Development Application No.: SSD-10-444  
Description of Development: Blue Gum Community School  
Property: Lot A DP 327582  
1 Rosemead Road, Hornsby

Thank you for the opportunity to comment on the Environmental Impact Statement for the proposed Blue Gum Community School State Significant Development (SSD-10-444). Council officers have reviewed the submitted documentation available on the Major Projects web portal and the following comments are provided for consideration by the Department.

### ***Heritage Assessment***

Drawing No. **A100** Revision **H**

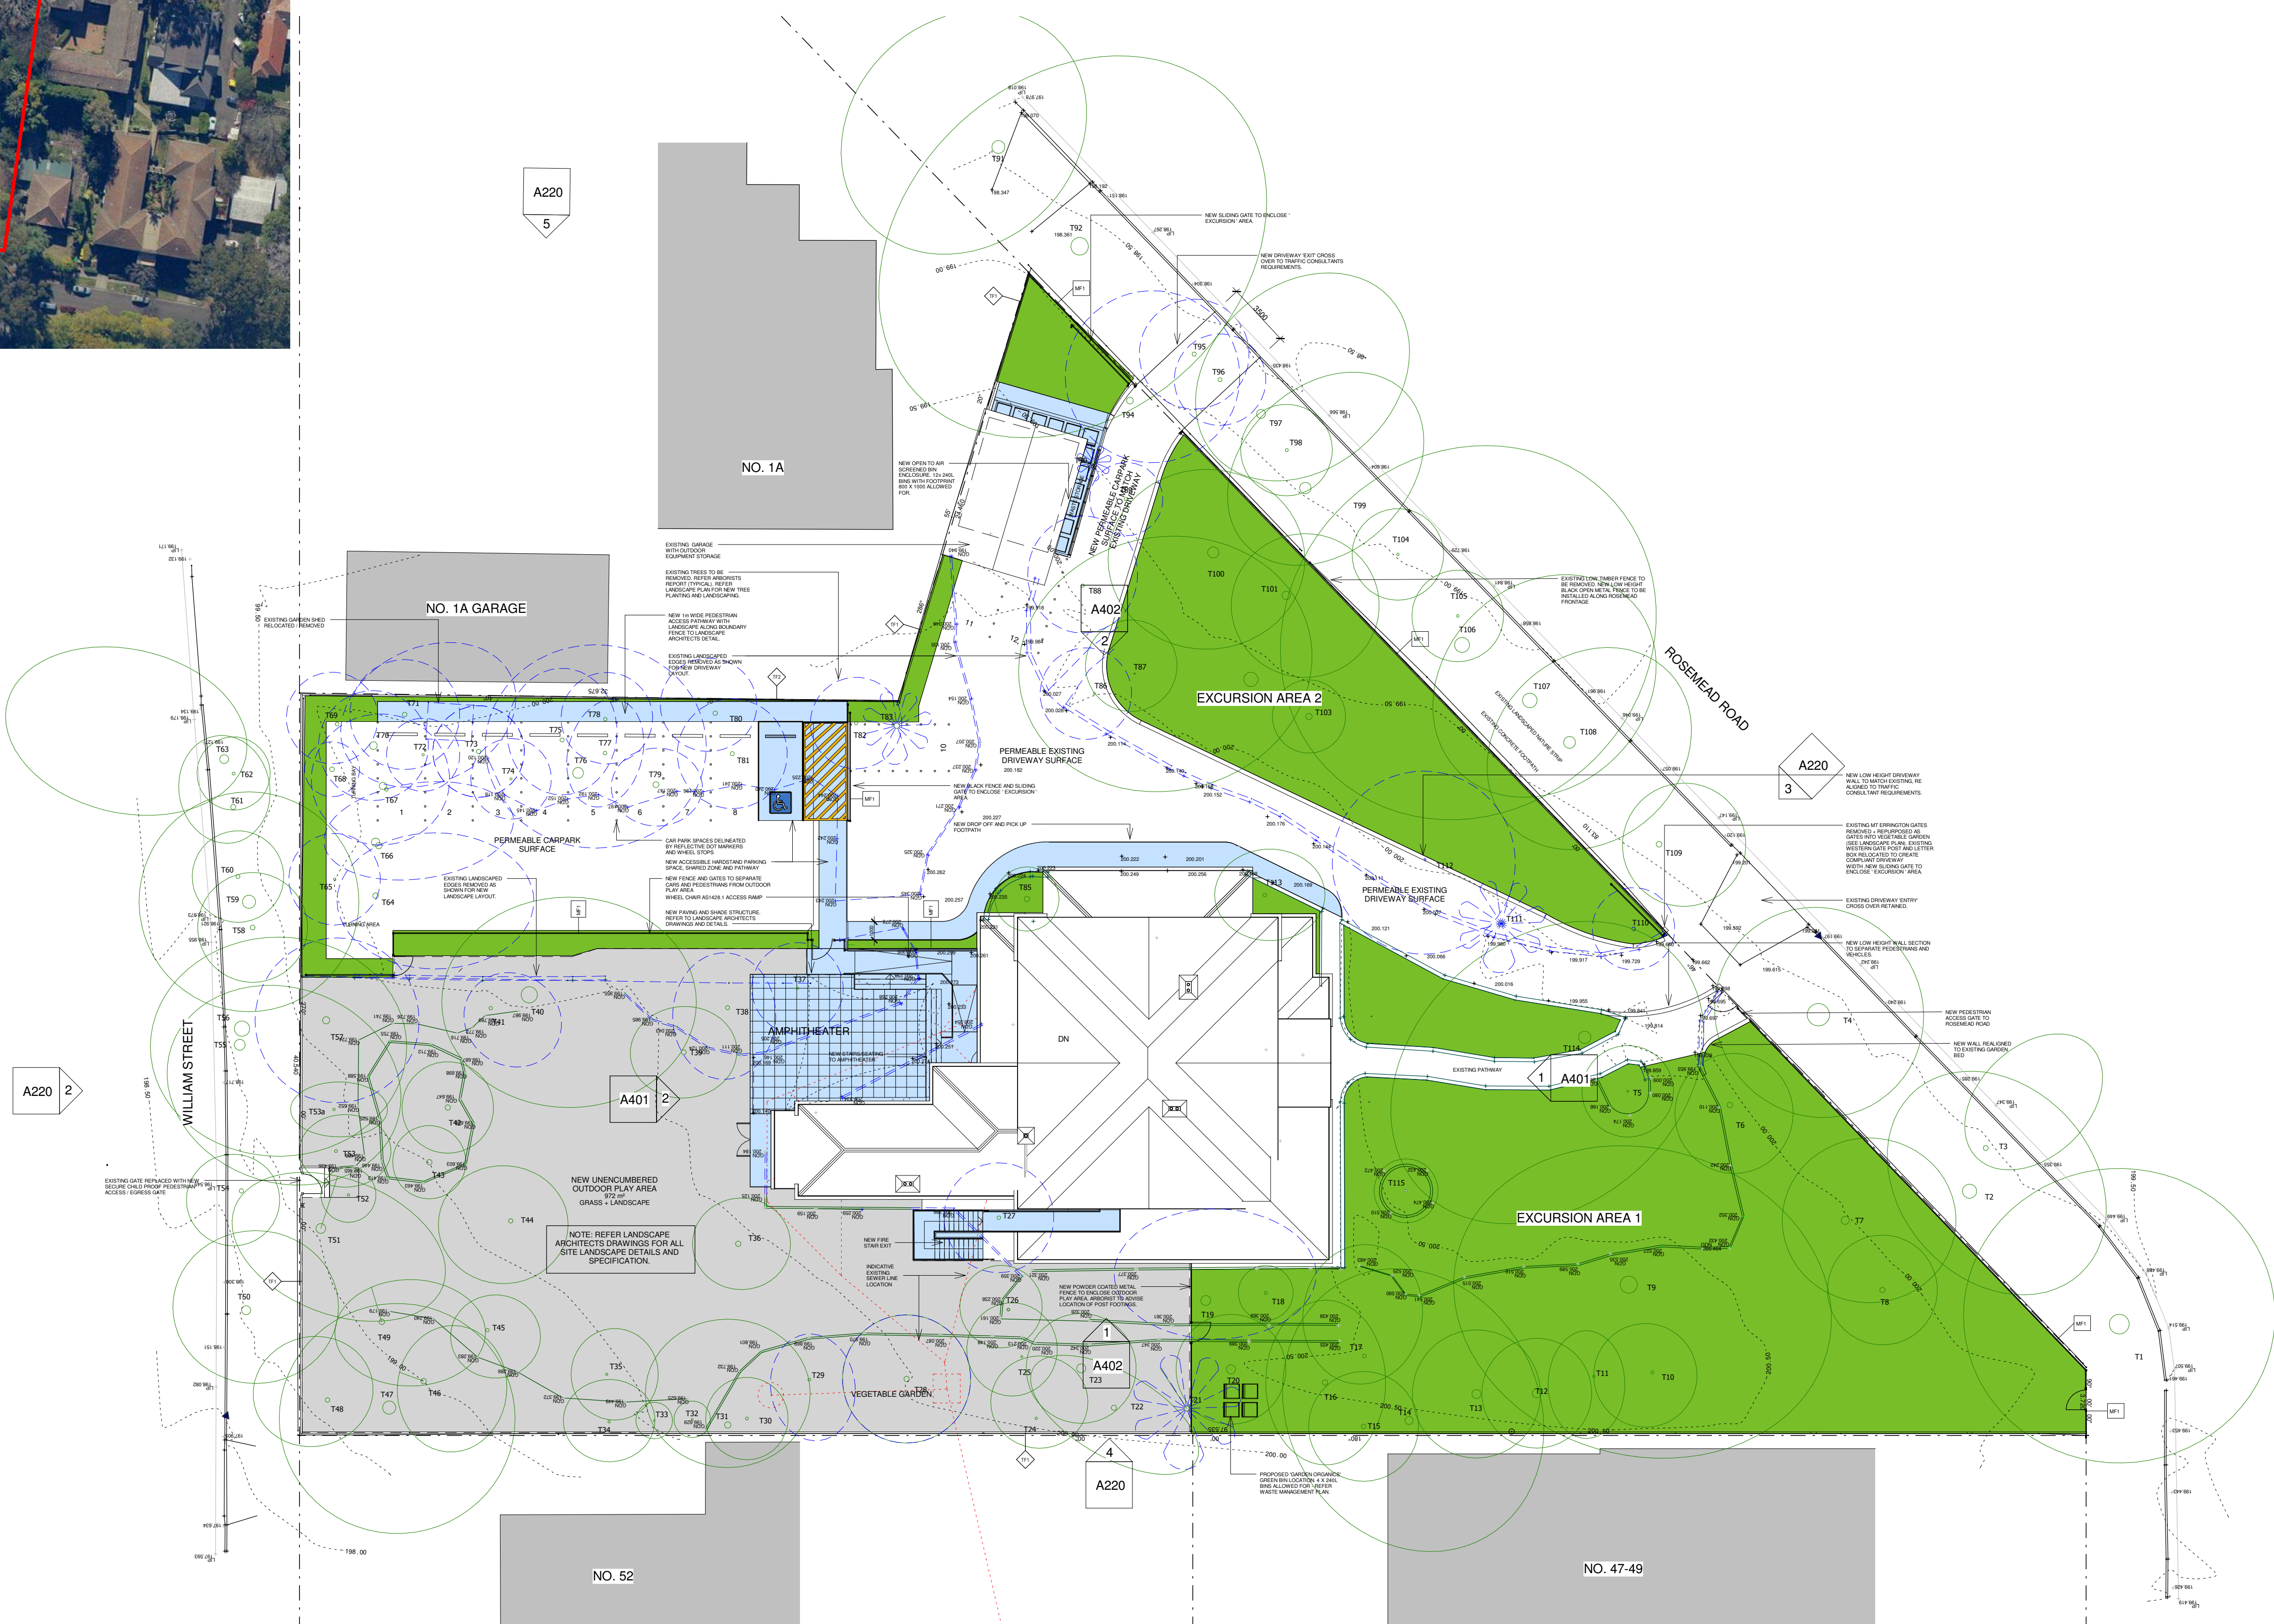
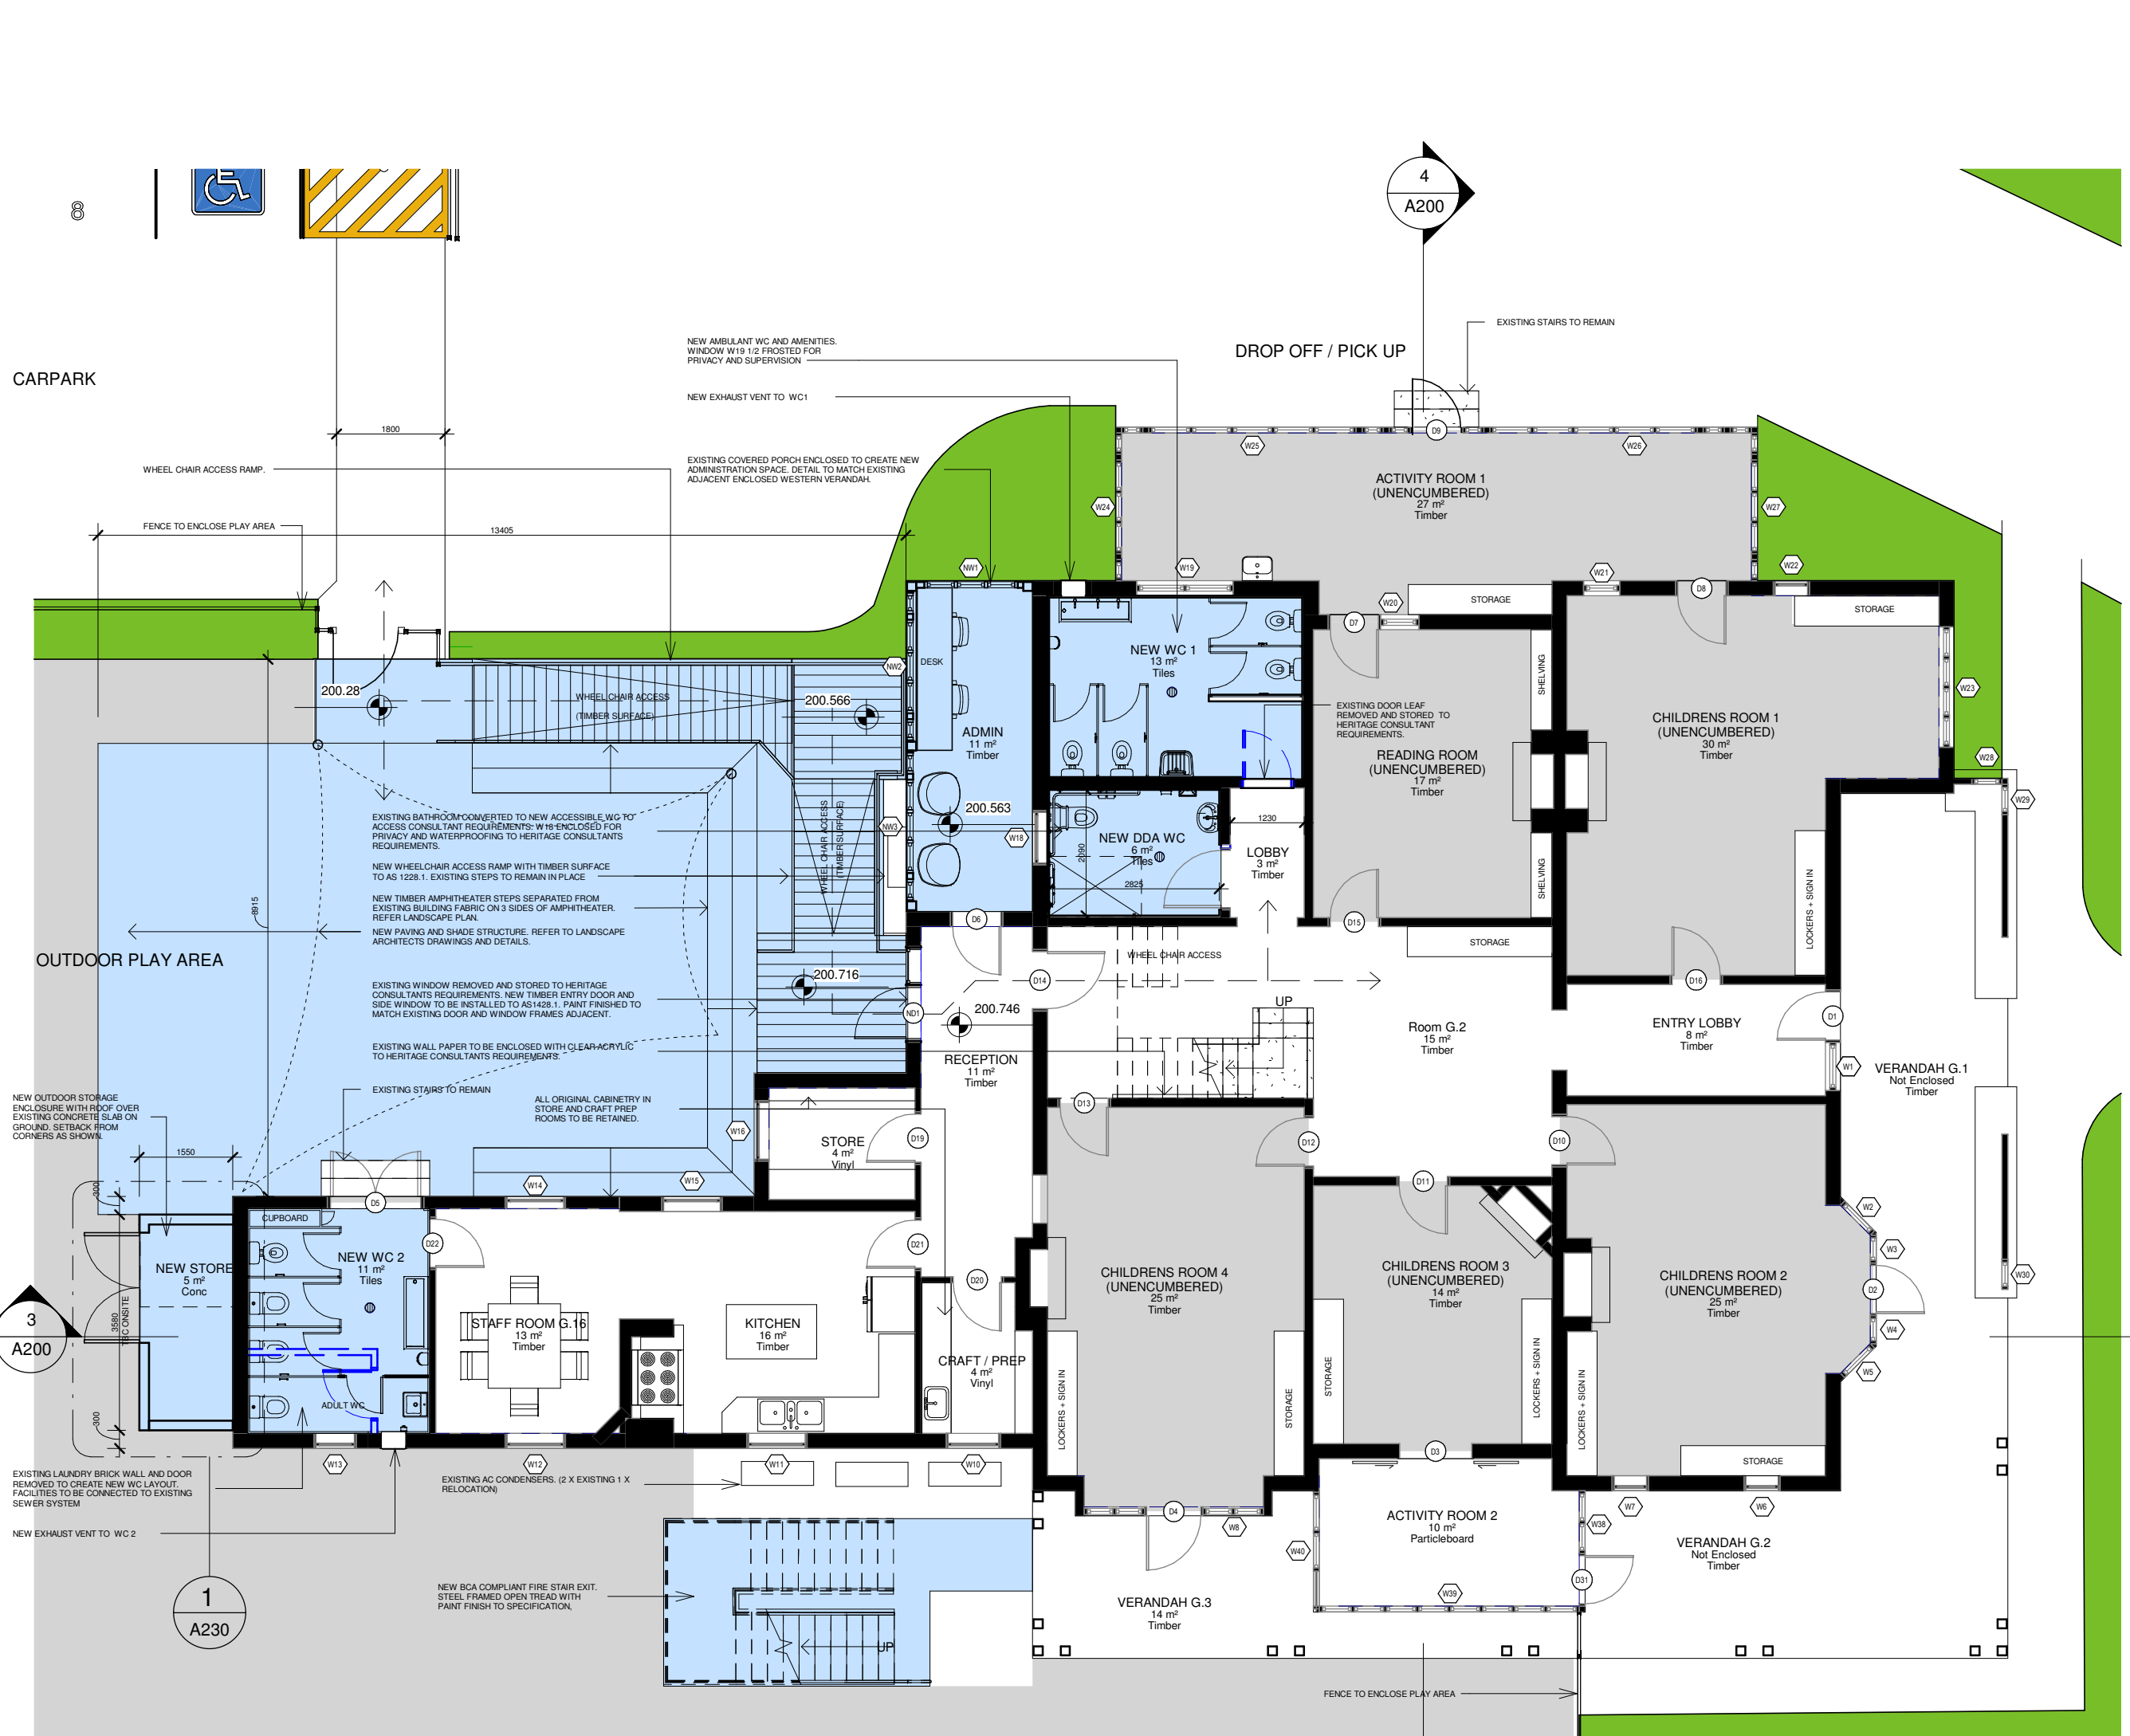
| <b>Proposed Works</b>    | <b>Impact</b>   | <b>Comment</b>  |
|--------------------------|---|---|
| 1. New Permeable carpark | Minor Impact<br>Amendments required<br>(see recommendation a) | <p>The SOHI fails to identify the heritage significance and impact of removing the tennis court. The tennis court is an original or early garden element remnant and representative of the historic use of the site. The date and significance of the remnant fencing in situ around the tennis court is unknown.</p> <p>Converting the area to a carpark may be a reasonable and acceptable adaptive reuse to service the new use of the site. The permeable pebble surface is complementary to the existing hard services on site. No heritage concerns are raised to the vegetation to be cleared over the former tennis court as they are modern additions to the site (post 1940s) and would be permissible for removal on heritage grounds should a refurbished tennis court be proposed.</p> |

| <b>Proposed Works</b>                    | <b>Impact</b>   | <b>Comment</b>   |
|--|---|--|
|  |   | <p>However, the original dimensions of the tennis court should be retained and interpreted through the placement and style of perimeter planting and fencing. The existing stone edging to the tennis court is possibly original and should be retained and used within the landscape plan. Any new fencing within the site should be based on historic evidence or be historically accurate to the period of the dwelling.</p> <p>Amendments to the Landscape Plan should be submitted to show retention of the tennis court dimensions, interpretation of the significant elements and appropriate fencing to meet heritage and regulatory requirements with a revised heritage impact assessment and justification for the alternative design.</p> <p>An alternative solution should also be investigated for the proposed concrete accessible path to meet heritage and regulatory requirements.</p> <p><b><i>The proposal complies with Section 9.2.3 Desired Outcome (a); Prescriptive Measure (a) and (d).</i></b></p> <p><b><i>The proposal does not comply with Section 9.2.3 Desired Outcome (b); Prescriptive Measures (b) and (c).</i></b></p> |

| <b>Proposed Works</b>                   | <b>Impact</b>  | <b>Comment</b>  |
|---|--|---|
| 3. New Driveway exit onto Rosemead Road | Unsympathetic Impact<br>Amendments required (see recommendation c) | <p>Concern is raised about the new driveway placement. It would removal 10 contributory trees and have an unsympathetic impact on the landscape aesthetics of the site and contribution to the streetscape. An alternative solution should be investigated to provide the second driveway off William Street and a supporting heritage impact assessment with justification of the alternative design to provide the least impact to the significant trees on site.</p> <p>No concerns are raised to the proposed driveway materials to match the existing hard surfaces on site with a brick edging and pebble surface.</p> <p><b>The proposed tree removal does not comply with Section 9.2.3 Desired Outcomes (a) and (b); Prescriptive Measures (a), (b), (d) and (c).</b></p> <p><b>The new driveway materials comply with Section 9.2.1 Desired Outcomes (a) and (c); Prescriptive Measure (c).</b></p> |

| <b>Proposed Works</b>  | <b>Impact</b>  | <b>Comment</b>   |
|--|--|--|
| 4. Existing Mount Errington gates and posts                                      | Adverse Impact<br>Amendments required (see recommendation d) | <p>The existing gates and posts are original, highly significant and a landmark feature of the site and HCA with views to, and from, the public domain. Removal, relocation and repurposing of elements would have a detrimental impact on the integrity of the site, the interpretation of the property and its landmark status within the HCA.</p> <p>The existing entry gates and posts should remain insitu. An alternative design solution should be investigated to meet heritage requirements.</p> <p><b>The proposal does not comply with Section 9.2.4 Desired Outcomes (a); Prescriptive Measures (a) and (b).</b></p> |

| <b><i>Proposed Works</i></b>  | <b><i>Impact</i></b>  | <b><i>Comment</i></b>  |
|---|---|--|
| 6. New powder coated metal fencing and egress/access gates to William Street, Rosemead Road, to separate the carpark and sliding gates to driveway entries. | Adverse impact<br>Amendments required<br>(see recommendation f) | <p>The powder coated metal fencing and gates do not complement the heritage significance of the property, the architectural style of the dwelling or the streetscape character of the HCA. They would be obtrusive, modern and unsympathetic elements to the Rosemond Avenue and William Street boundaries, as well as visually obstructive to the garden placed within the site.</p> <p>Any new fencing within the setting and around the curtilage of the item should be based on historic evidence, historically accurate to the period and reflect the materials used within the main dwelling. Alternative fencing and gates should be proposed to meet heritage and regulatory requirements.</p> <p><b><i>The proposal does not comply with Section 9.2.4 Desired Outcome (b); Prescriptive Measures (c), and (d); Section 9.3.3 Desired Outcomes (a) and (c); Prescriptive Measures (j), and (k).</i></b></p> |

| a) New permeable carpark | <ul style="list-style-type: none"> <li>• <b><i>The proposal does not comply with Section 9.2.3 Desired Outcome (b); Prescriptive Measures (b) and (c).</i></b></li> <li>• Amendments to the Landscape Plan to show retention of the tennis court dimensions, interpretation of the significant elements and appropriate fencing to meet heritage and regulatory requirements</li> <li>• Alternative material and finish for the new concrete accessible path to meet heritage and regulatory requirements.</li> </ul> |

| c) New Driveway exit onto Rosemead Road  | <ul style="list-style-type: none"> <li>• <b><i>The proposed tree removal does not comply with Section 9.2.3 Desired Outcomes (a) and (b); Prescriptive Measures (a), (b), (d) and (c).</i></b></li> <li>• Alternative solution investigated to provide the second driveway off William Street to minimise impact of significant trees on site.</li> <li>• A revised heritage impact assessment and justification for the alternative design</li> </ul>      |

| d) Existing Mount Errington gates and posts                | <ul style="list-style-type: none"> <li>• <b><i>The proposal does not comply with Section 9.2.4 Desired Outcomes (a); Prescriptive Measures (a) and (b).</i></b></li> <li>• The original gates and posts should be retained in-situ;</li> <li>• Alternative solution to meet heritage requirements.</li> </ul>  |
| f) New powder coated metal fencing and egress/access gates | <ul style="list-style-type: none"> <li>• <b><i>The proposal does not comply with Section 9.2.4 Desired Outcome (b); Prescriptive Measures (c), and (d); Section 9.3.3 Desired Outcomes (a) and (c); Prescriptive Measures (j), and (k).</i></b></li> <li>• Alternative design, finishes and materials to meet heritage and regulatory requirements.</li> </ul> |

6 STAFF ONLY BALCONY ELEVATION
1 : 20

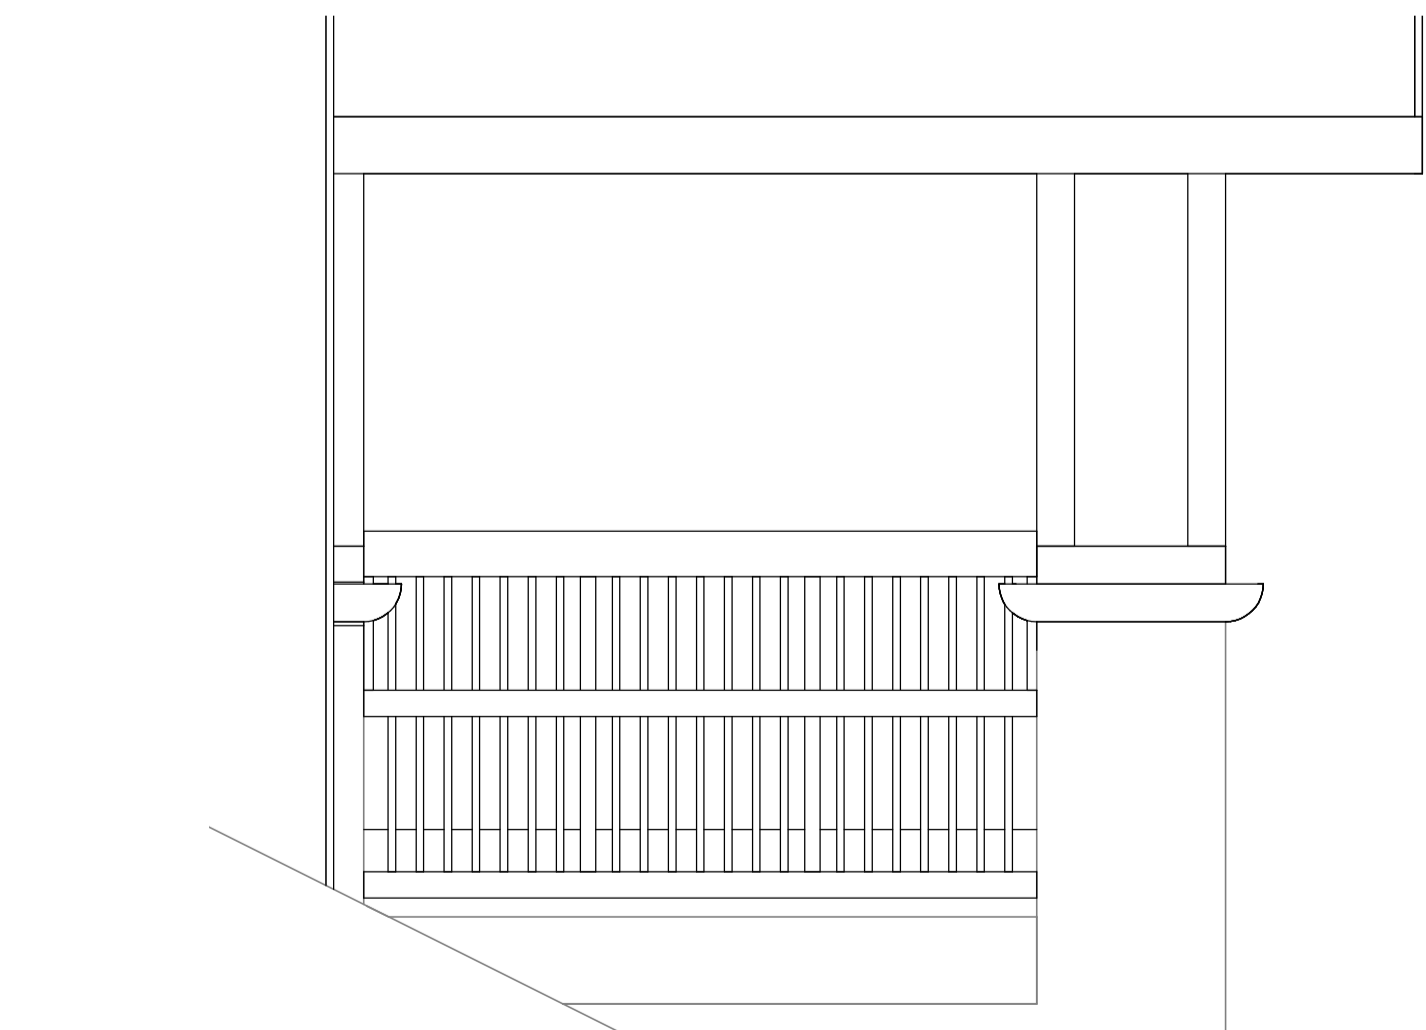
| <b><i>Proposed Works</i></b>                | <b><i>Impact</i></b>  | <b><i>Comment</i></b>  |
|---|---|--|
| 11.Raised balustrade on first floor balcony | Adverse impact<br>Amendments required<br>(see recommendation k) | <p>The first floor balcony and it's architectural detail is highly significant and distinctive to the Arts and Crafts features of the building. The balustrade amendment is not historically accurate, would remove original fabric from the primary façade, and would have an irreversible detrimental effect on the integrity of the item and</p>  |

| <b>Proposed Works</b> | <b>Impact</b> | <b>Comment</b>  |
|-----------------------|---------------|---|
|                       |               | <p>views from the streetscape. The original balustrade should be retained. An alternative solution should be investigated to meet heritage and regulatory requirements.</p> <p><b><i>The proposal does not comply with Section 9.2.1 Desired Outcomes (a) and (d); Prescriptive Measures (a), (c), and (g).</i></b></p> |
